# HIGH MESA Consulting Group

2017.014.2  
September 26, 2017

RE: Letter Explaining How EPC Conditions Have Been Addressed – Project # 1005237  
Request for Final Sign-Off for EPC Approved SDP for Building Permit and SDP for  
Subdivision.  
Tracts A-1, Mark 3S Holly Development

**SITE DEVELOPMENT PLAN FOR BUILDING PERMIT (2017 AMENDMENT)
 MARK 3S HOLLY DEVELOPMENT**

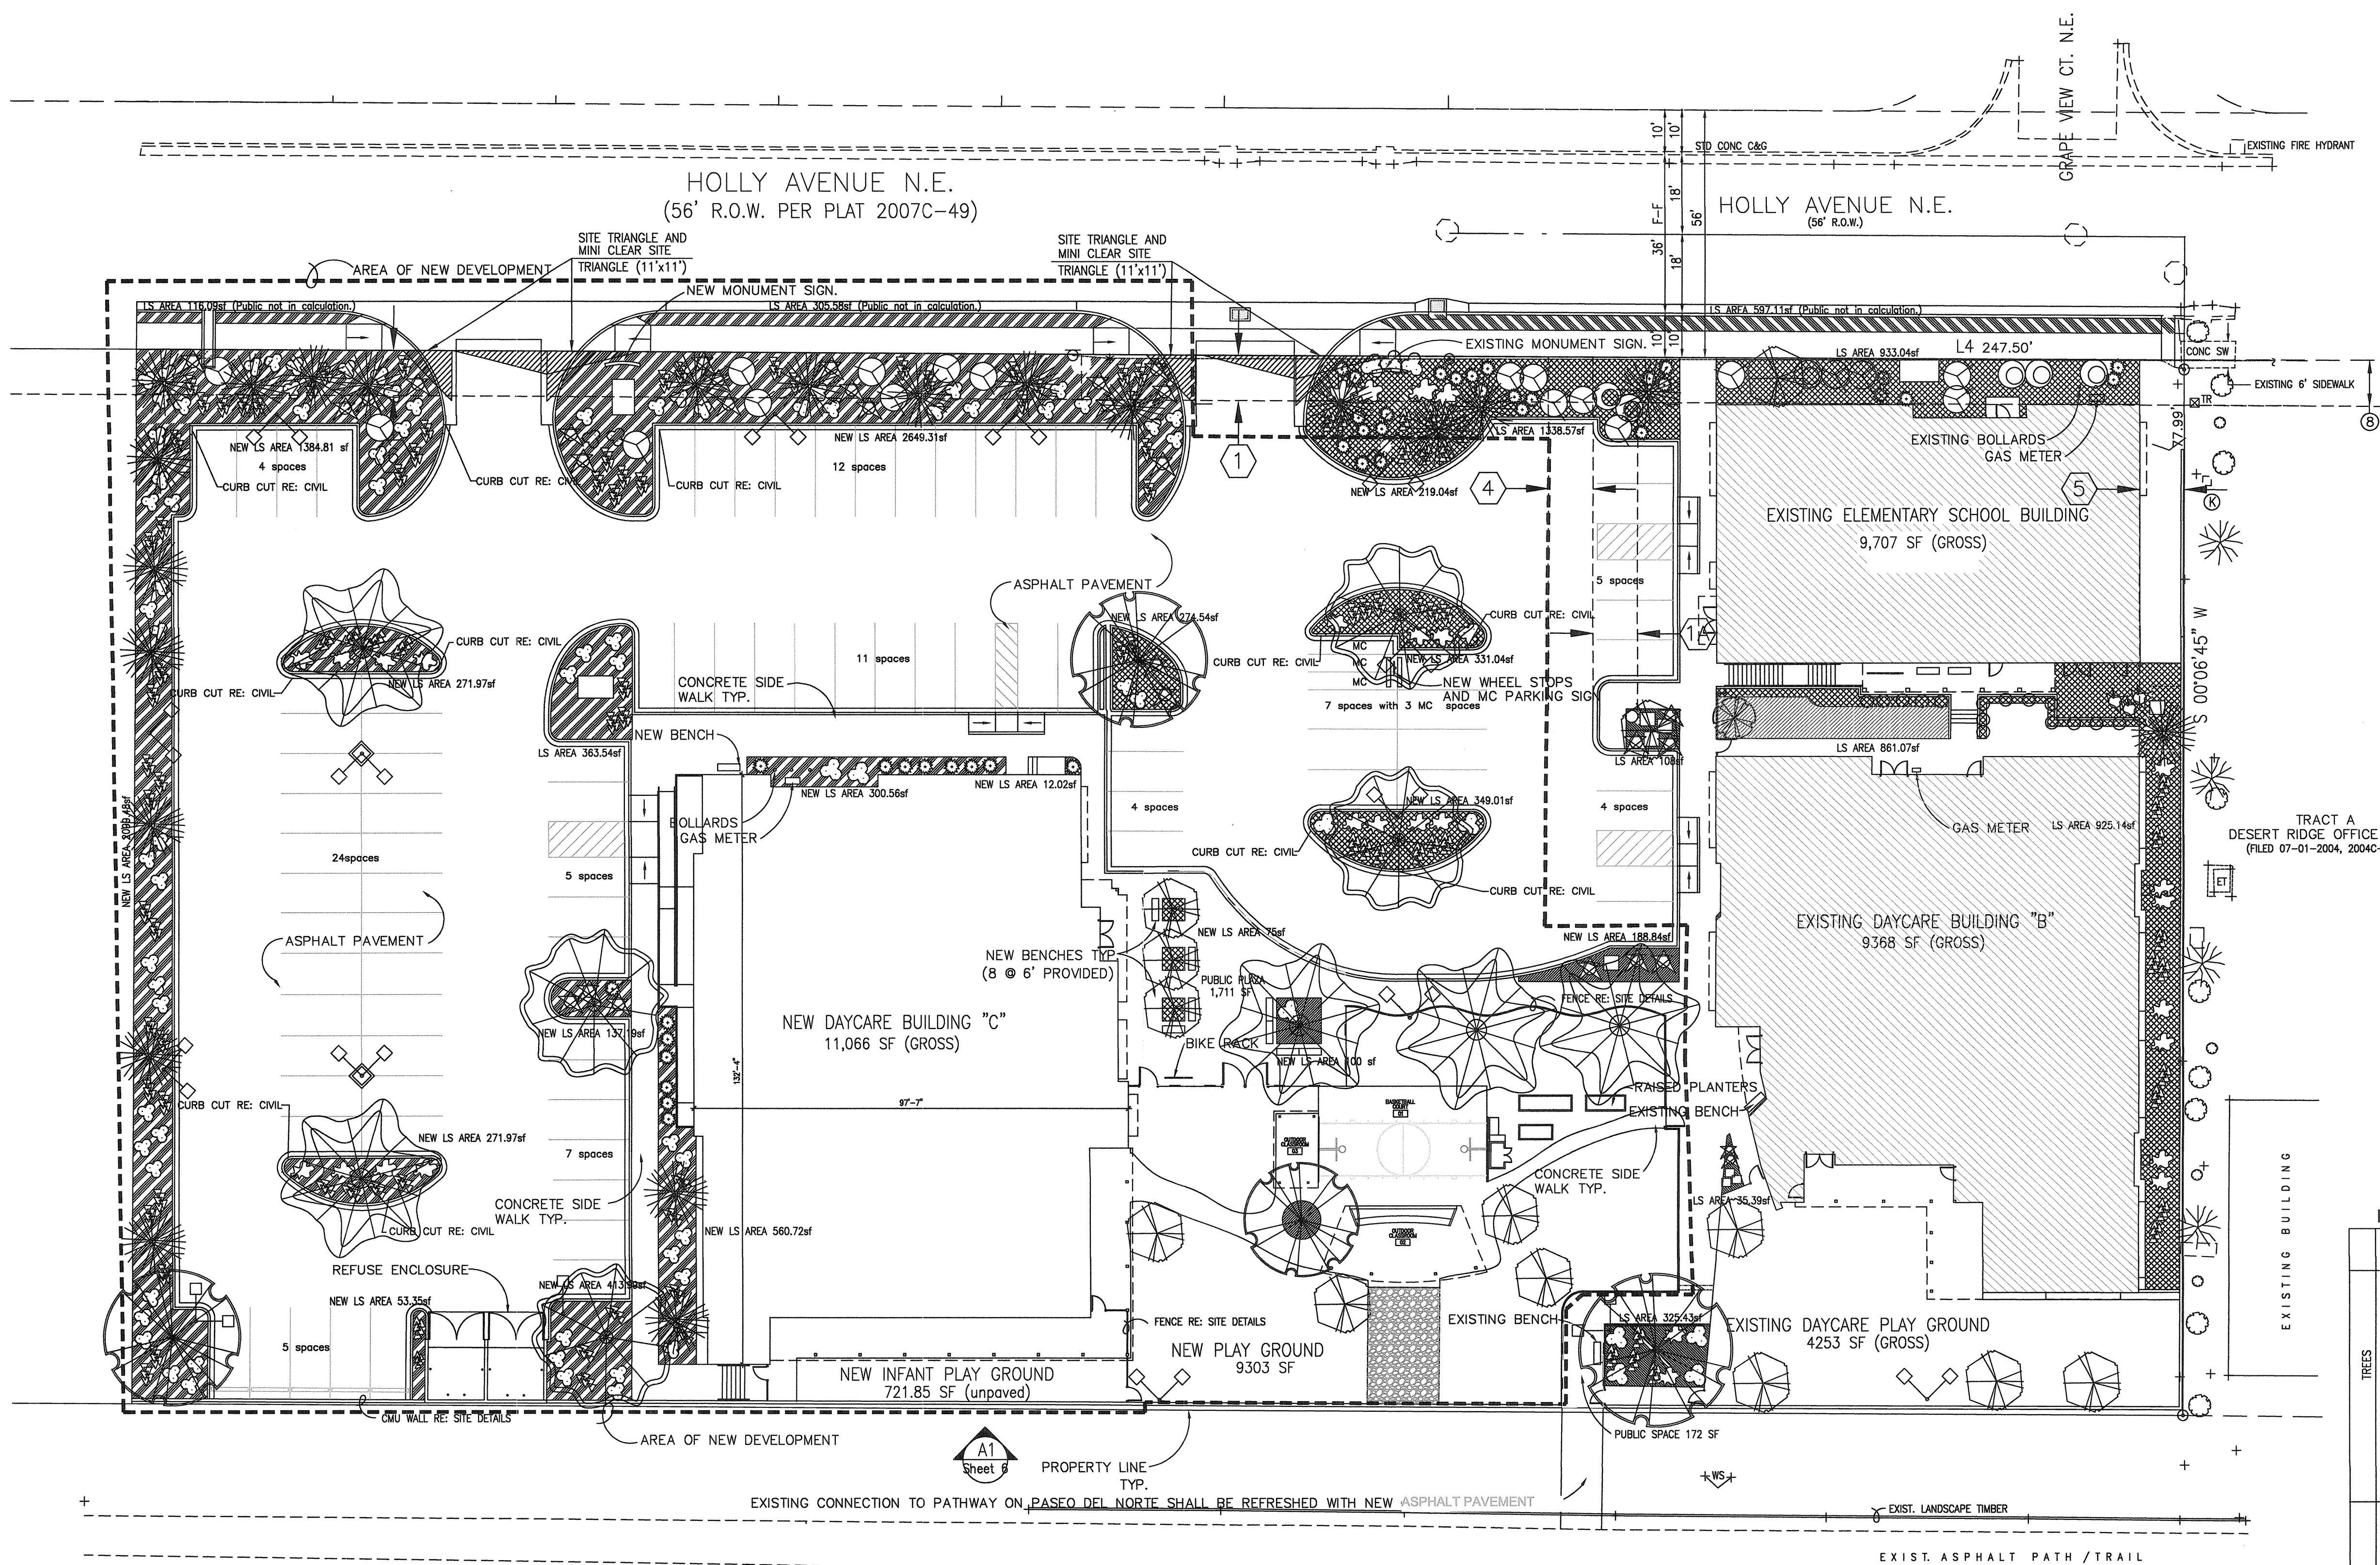
- 3) The proposed lot lines shall be labeled and clearly indicated, and redrawn to show a single tract. *-Proposed lot lines are now labeled and clearly indicated, and redrawn to show a single tract*

- B. The MC spaces on Tract C will need to be relocated to an area visible from the building’s main entrance pursuant to Zoning code 14-16-3-1 (C)(2). *-All three MC spaces are now visible from the building’s main entrance.*

- C. Parking shall be reduced to comply with LCSDP Regulation 12R-3 (maximum parking allowed is 10% plus the minimum required amount). *-Total parking was reduced from 98 spaces to 88 spaces to fall under the maximum parking allowed limit of 89.*

- B. A pedestrian connection shall be provided from the sidewalks to the principal customer entrance of Building C [Zoning Code 14-16-3-1(H)] - *A pedestrian connection is provided from public sidewalk to the Building C entrance. See Sheet 1 for pathway.*

- 8) Open Space & Common Areas
    - A. A plaza area, courtyard, patio seating area, or a pedestrian plaza with benches shall be added (LCSDP 8R-2) *-A public plaza with benches was added to the east of building C.*

- A. The view lines shall be indicated on the main sheet (Sheet 1). -*View lines are now shown on Sheet 1.*
- B. The dimensions and distances used on the view sheet shall match those on the site plan. -*Dimensions and distances shown on View 1 sheet now match the Site Plan.*

- G. Clearly identify all changes to existing site. The site plan does not show what changes are being made to the existing buildings or site. *-A large dashed screened line on Sheet 1 identifies existing site to remain and proposed improvements.*

DRAWN BY: BG
 REVIEWED BY: BG
 DATE: 08/01/2017
 PROJECT NO.: F 2017
 DRAWING NAME: LANDSCAPE PLAN

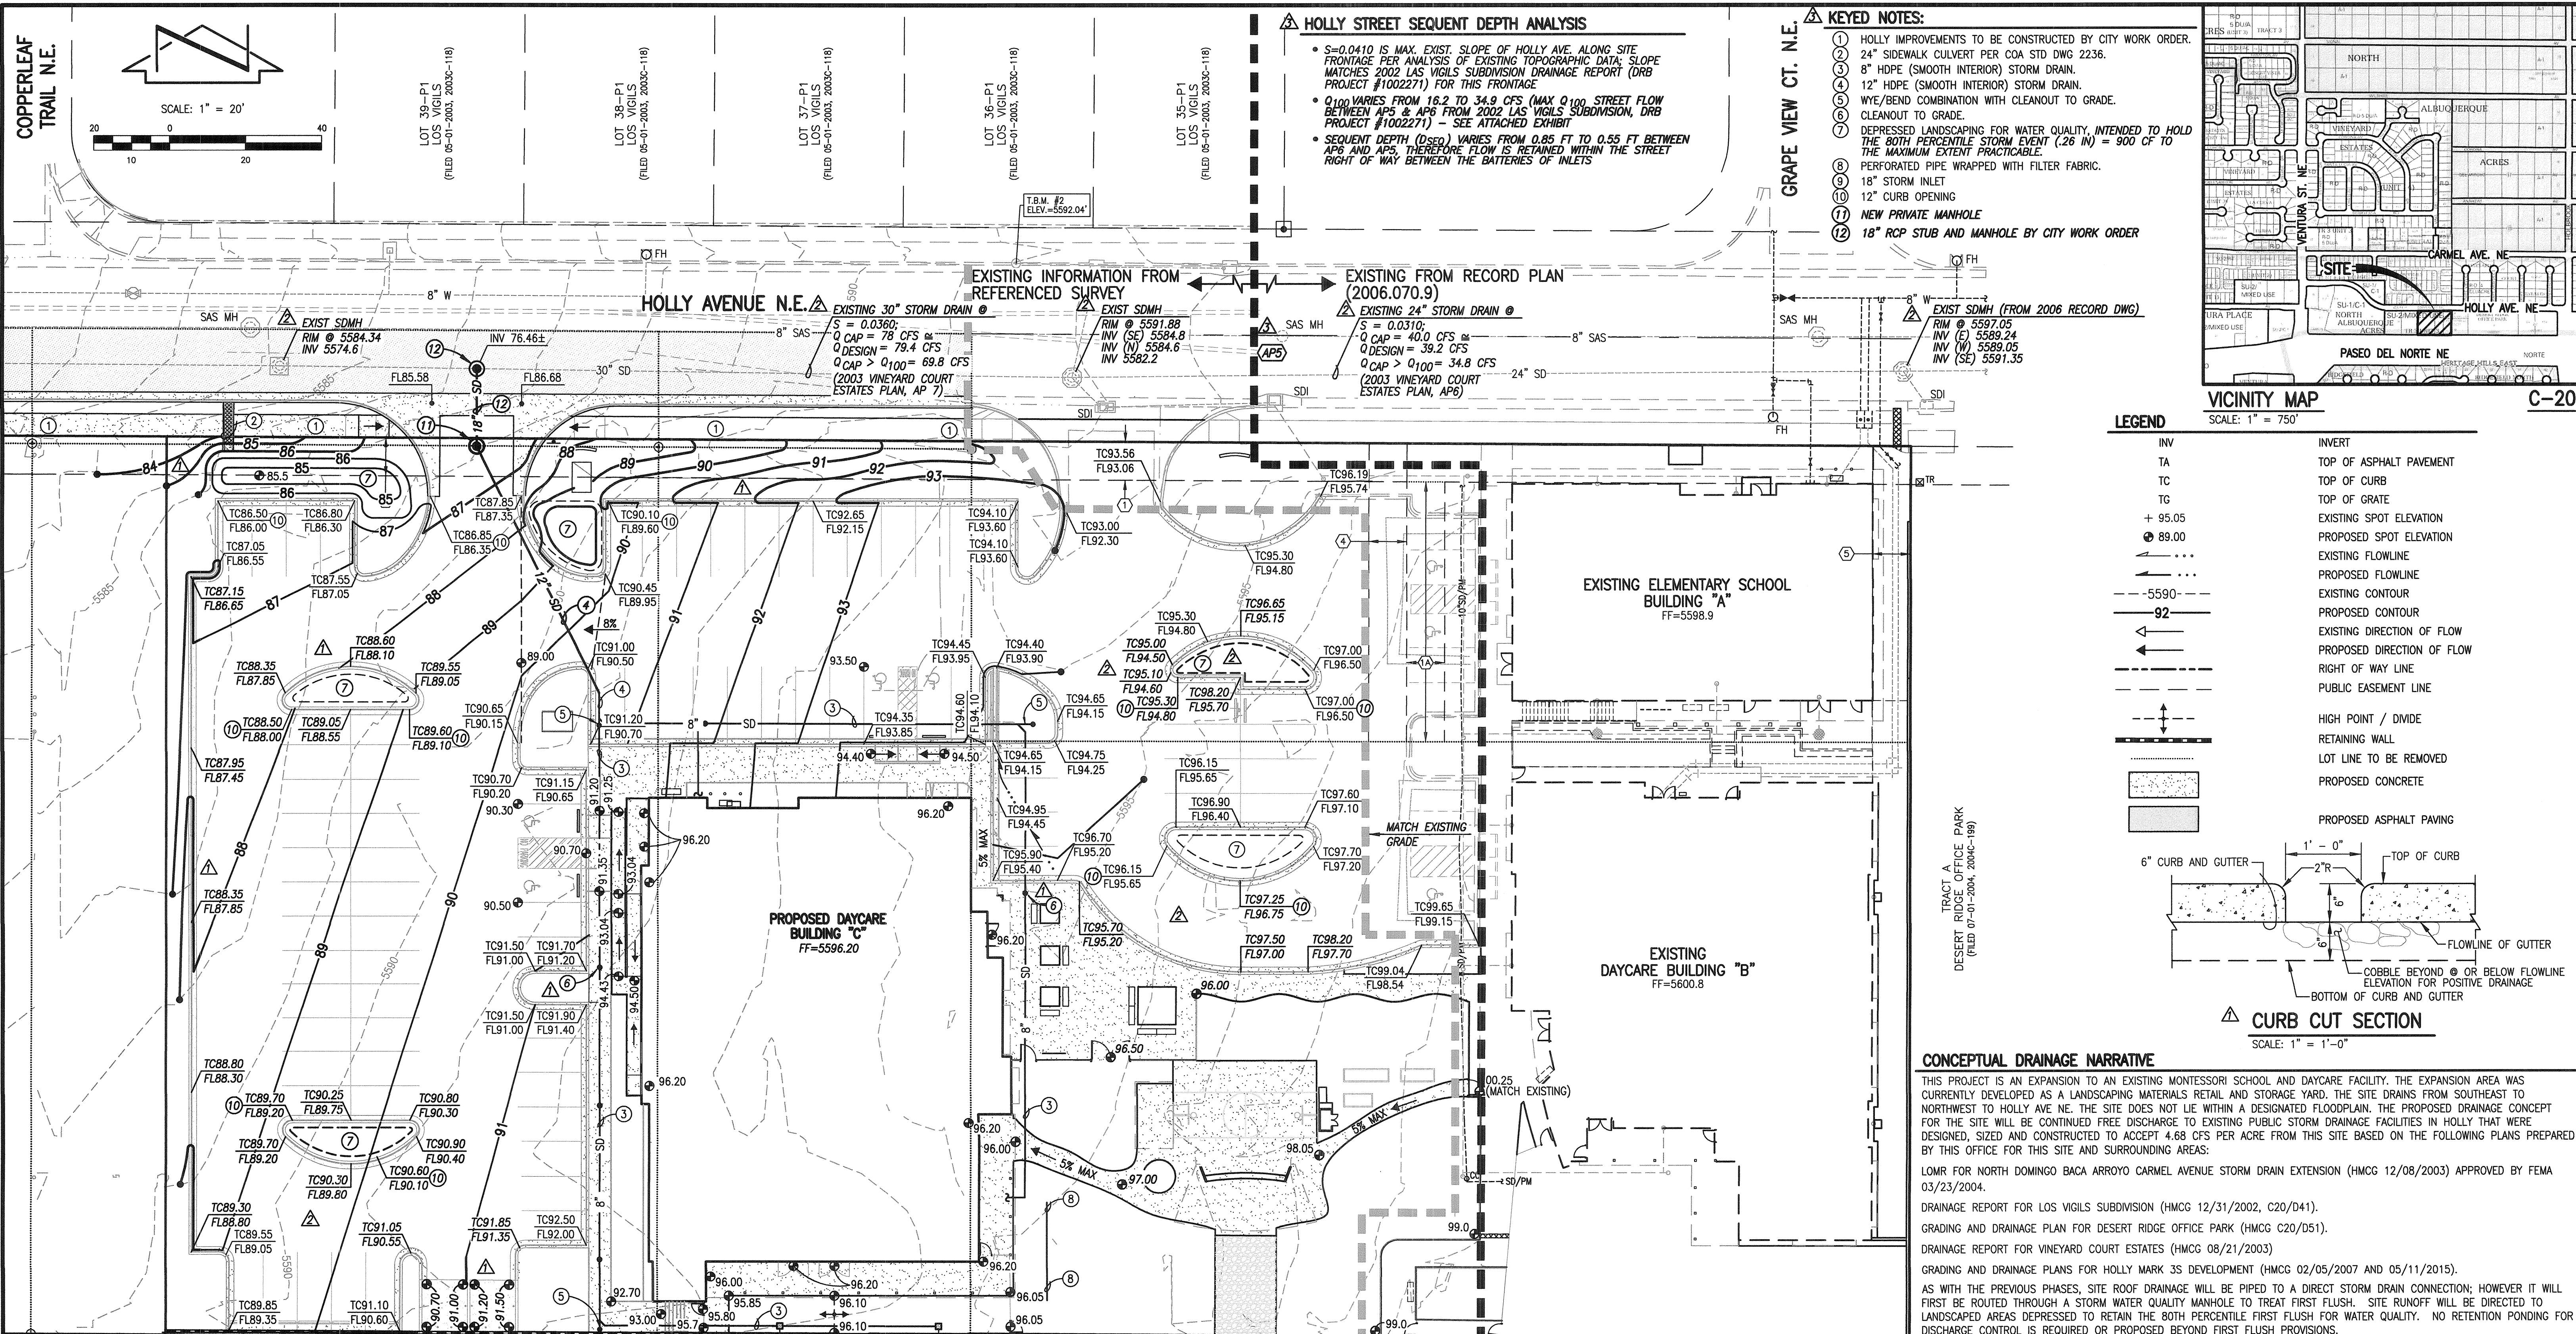
- A. The proposed landscaping plan shall accurately depict the existing landscape. -*Landscaping plan accurately depicts landscape to be replaced or revised with this proposal. Some previous plants have not survived and will be replaced.*

- B. The divided landscape area near the subject site's SW corner shall be enlarged to have enough space for a tree. -*Divided landscape area was enlarged.*

- C. The parking lot tree shall be changed to 13 (vitex are too small to count). -*Vitex were removed from parking lot tree count. Requirement was revised to 11 with new revisions.*

- D. A couple of large, canopy-forming, not multi trunk trees shall be added to the play area or the parking lot. -*A couple of large, canopy-forming, not multi trunk trees (London Plane Trees) were added to parking lot and play area.*

- E. Curb notches shall be shown on the landscaping plan and match those on the Grading and Drainage Plan. -*Curb notches now shown on landscaping plan now match the grading plan exactly.*

D. An existing overhead distribution line is located along the northern boundary of the subject property. On Sheet 2, Landscape Plan, the proposed tree selection along Holly Avenue NE, the Red Texas Oak, is not a compatible height at maturity with the existing overhead electric distribution facility along the northern boundary of the site. A shorter tree selection at mature height is necessary at this locations. PNM's landscaping preference is for trees and shrubs to be planted outside the PNM easement; however, if within the easement, trees and shrubs should be located to minimize effects on electric facility maintenance and repair. New trees planted near PNM facilities should be no taller than 25 feet in height at maturity to avoid conflicts with existing electric infrastructure. Trees at mature height that interfere with this electric line will be trimmed. It is necessary for the developer to contact PNM's New Service Delivery Department to coordinate electric service regarding this project. Contact: Mike Moyer, PNM Service Center, 4201 Edith Boulevard NE, Albuquerque, NM 87107 Phone (505) 241-3697 -*Red Texas Oak trees near electrical utilities have been replaced with pinon trees. Pinon tree's height at maturity is 25 feet which meets the height requirement listed above.*
